# CITY OF ALBUQUERQUE

**RE: Circle K – 9610 Eagle Ranch Rd. NW**  
**Temporary Certificate of Occupancy**  
**Engineer's Certification Date: 06/24/2025**  
**Engineer's Stamp Date: 12/22/23**  
**Hydrology File: C13D028**  
**Case # HYDR-2025-00224**

Based on the Engineer's Grading and Drainage Certification received 6/24/2025 and site visit on 6/25/2025, this letter serves as a conditional approval from the Hydrology Section for a 30-day Temporary Certificate of Occupancy for the Circle K located at 9610 Eagle Ranch Rd. NW to be issued by the Building and Safety Division. The following comment needs to be addressed prior to acceptance for Permanent C.O. of the above referenced project:

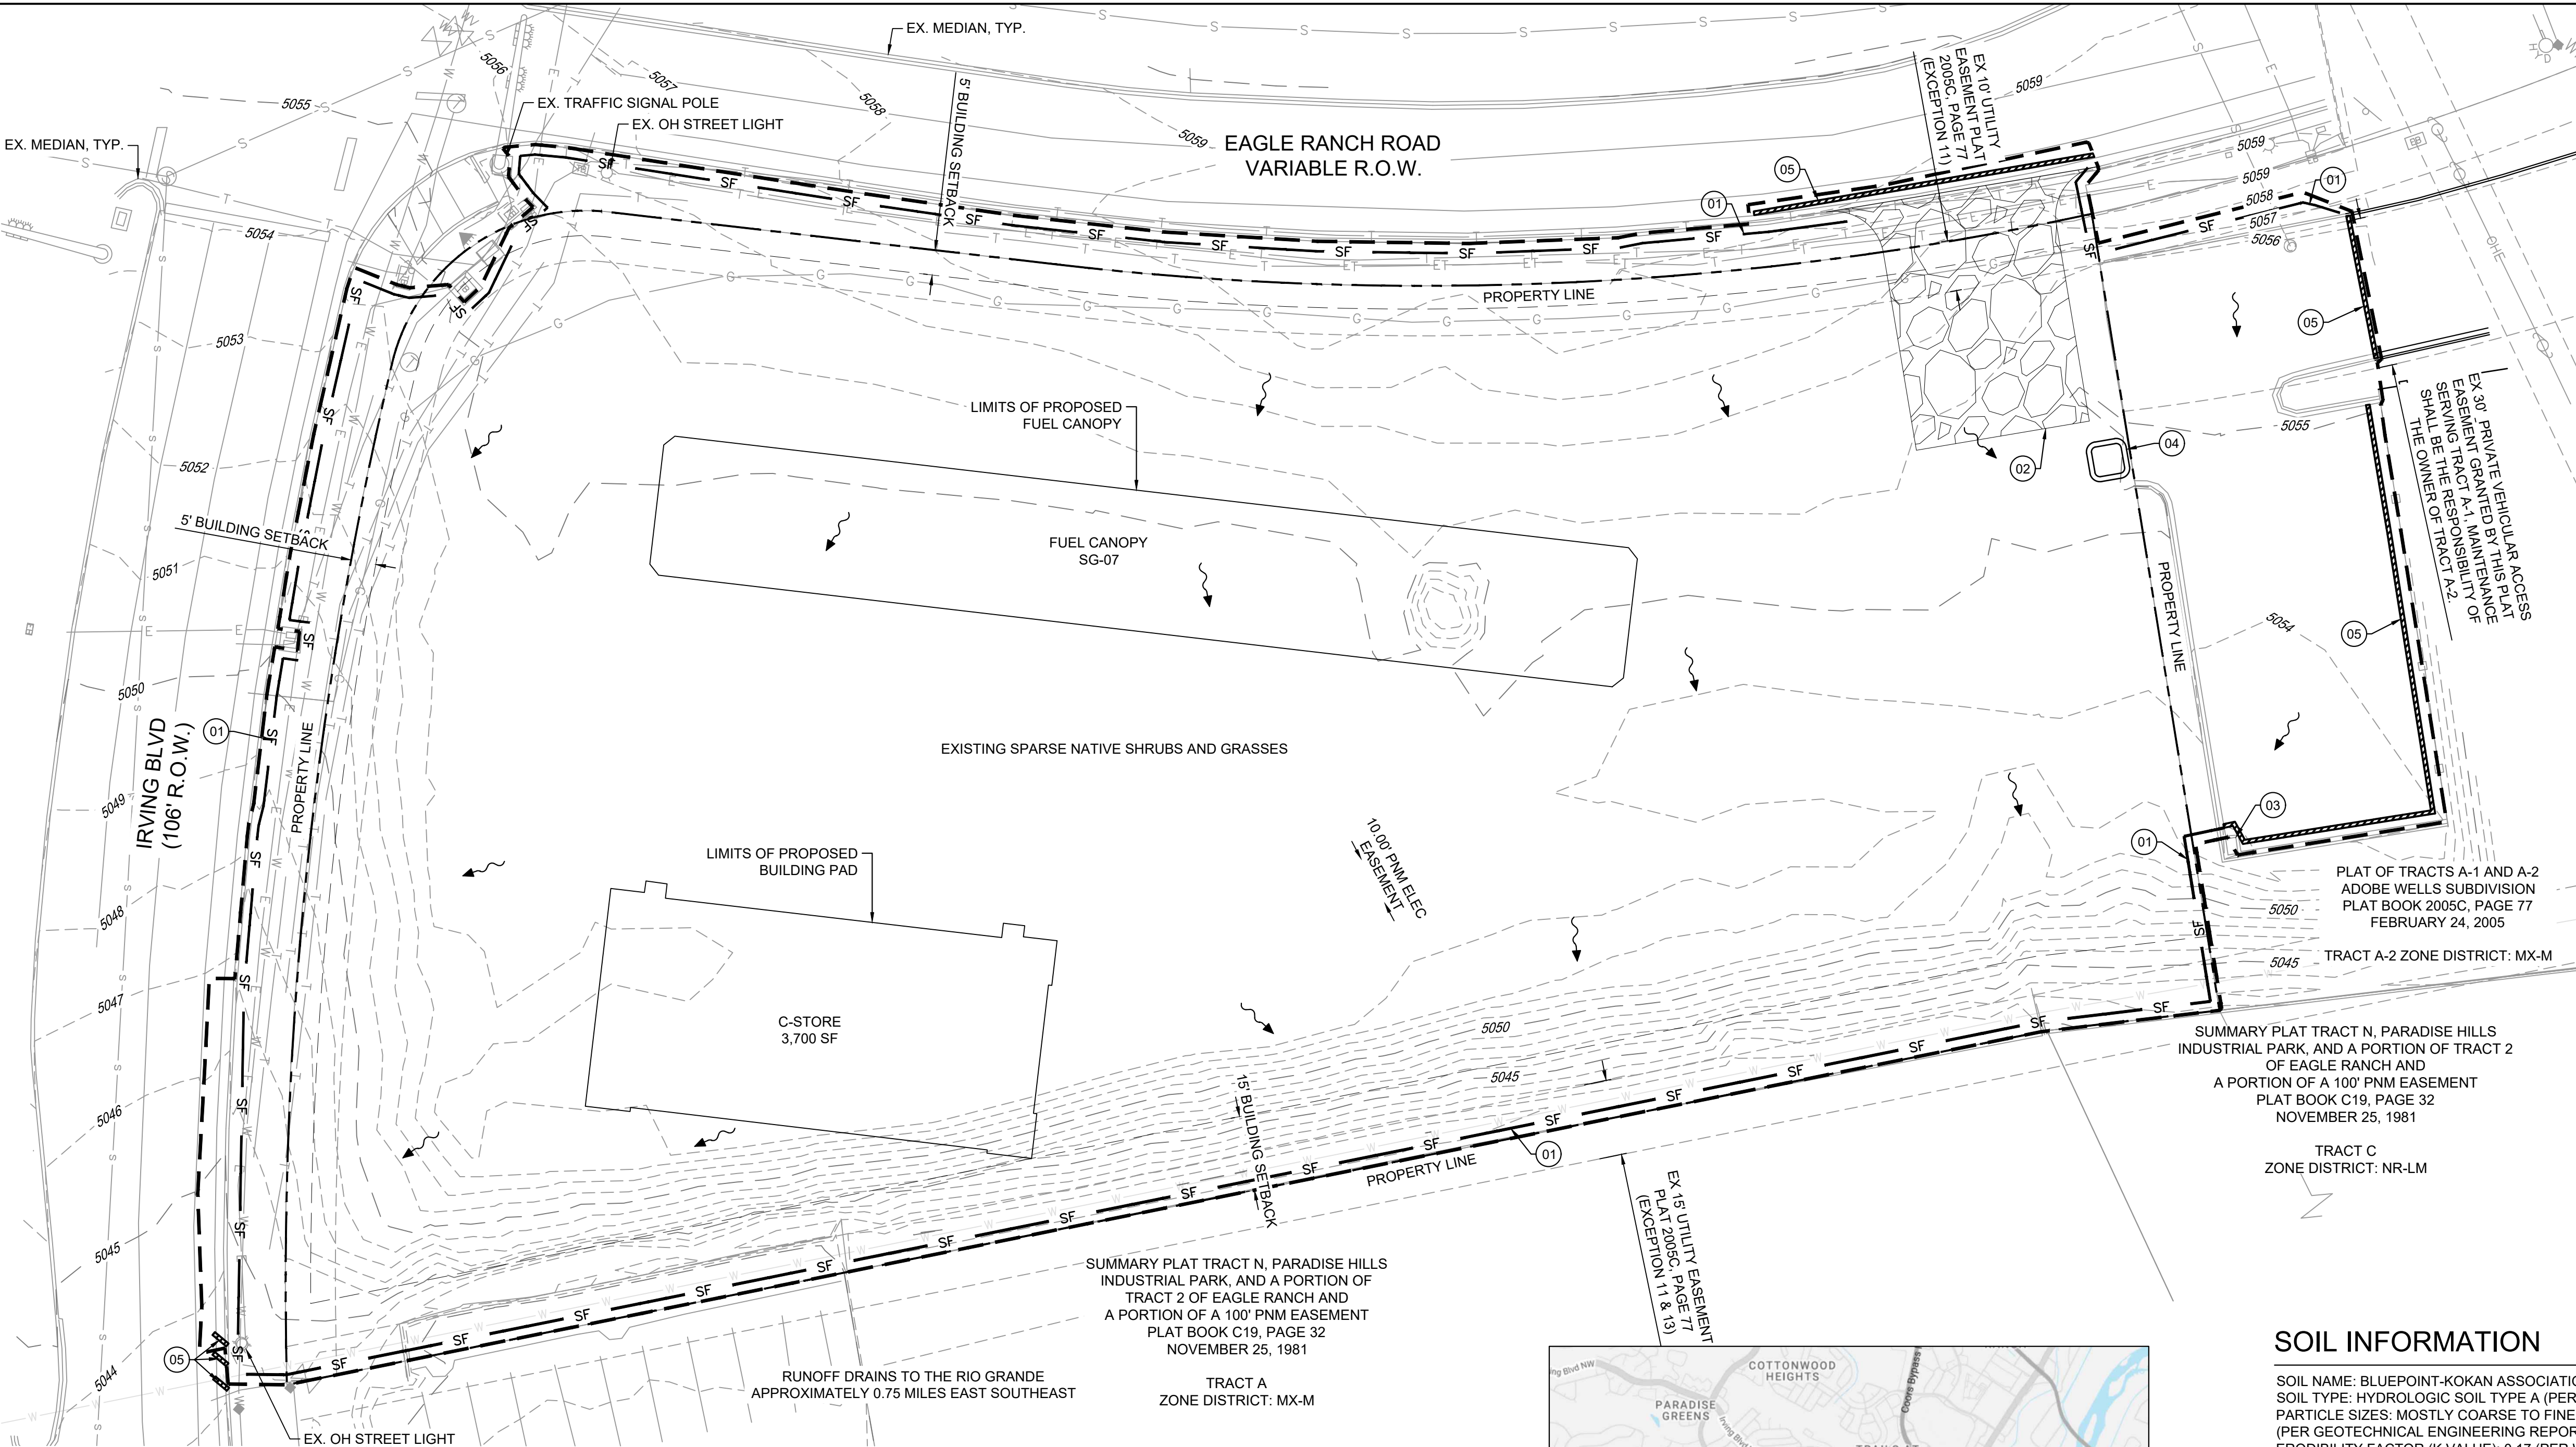
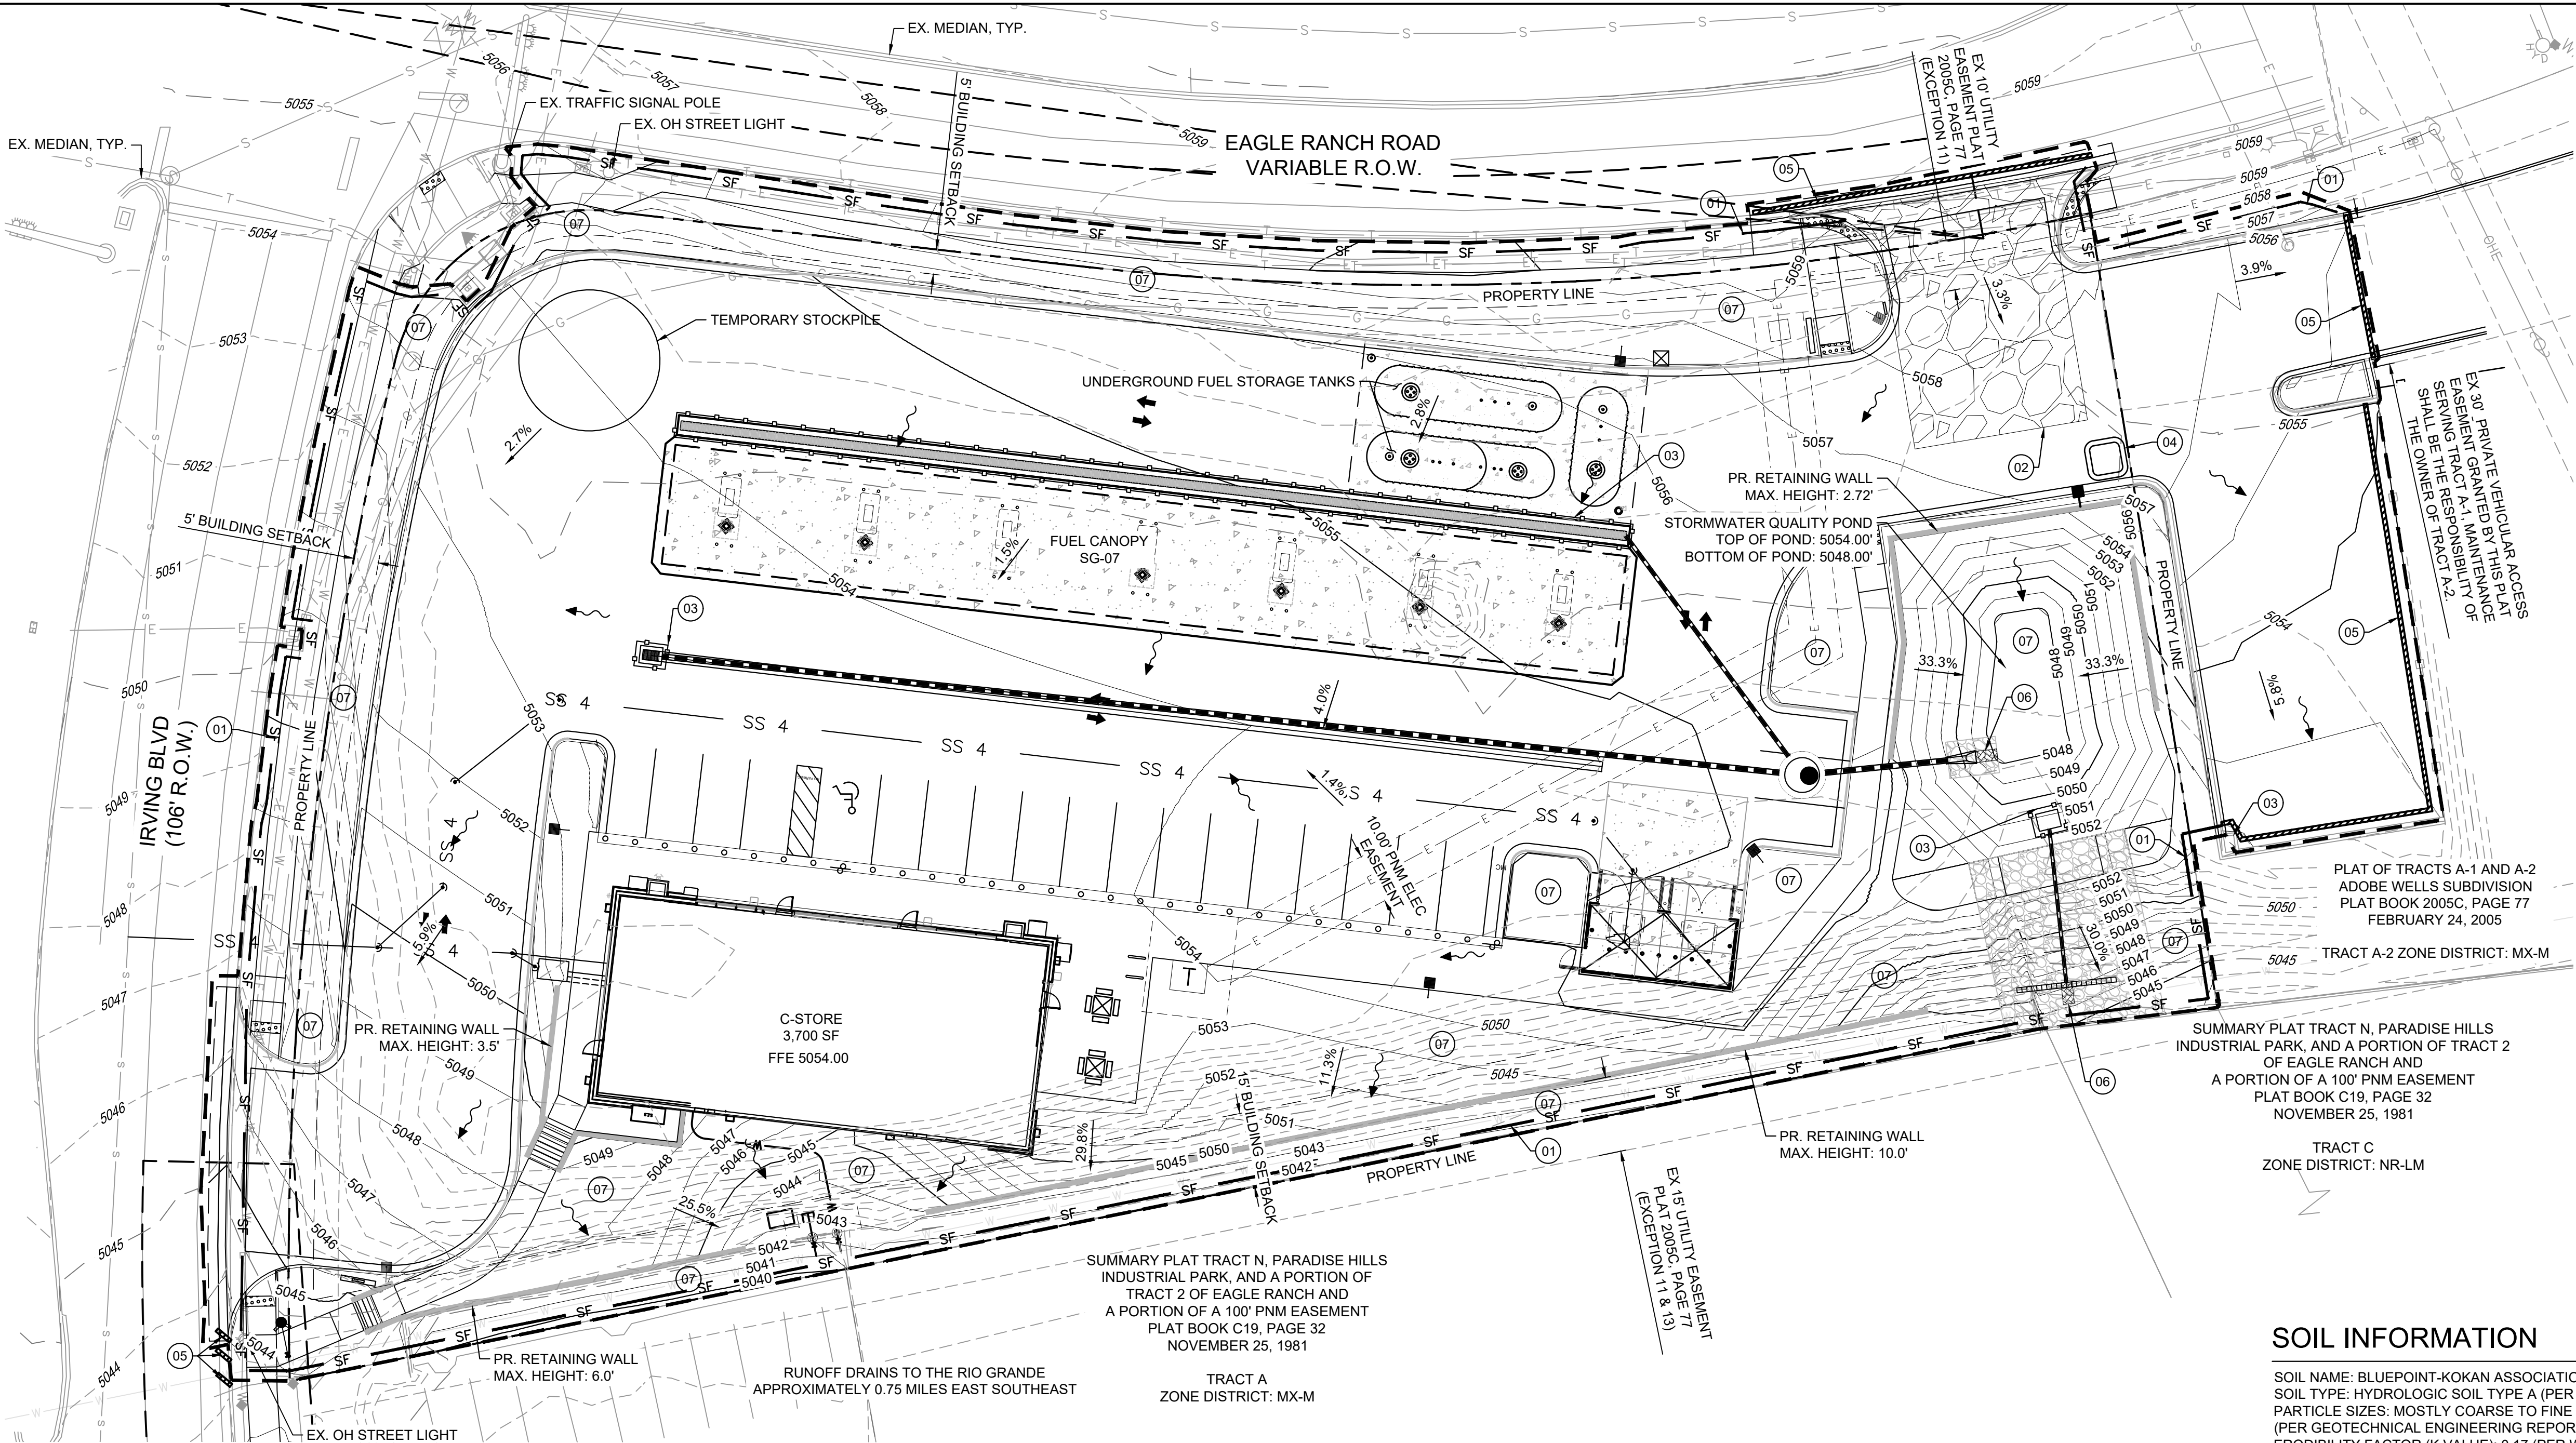
1. Complete the slope stabilization and erosion control needed for the east side of the lot.
2. Please provide the Drainage Covenant with Exhibit A for the stormwater quality pond per Article 6-15(C) of the DPM prior to Permanent Release of Occupancy. Please submit the original copies along with the **\$ 25.00** recording fee check made payable to Bernalillo County to Hydrology. In order to submit the DC, you will need to apply in ABQ-PLAN for a Covenant and upload the Drainage Covenant and Exhibit A (separate attachments). Then the originals and the filing fee are turned in to Hydrology for processing.
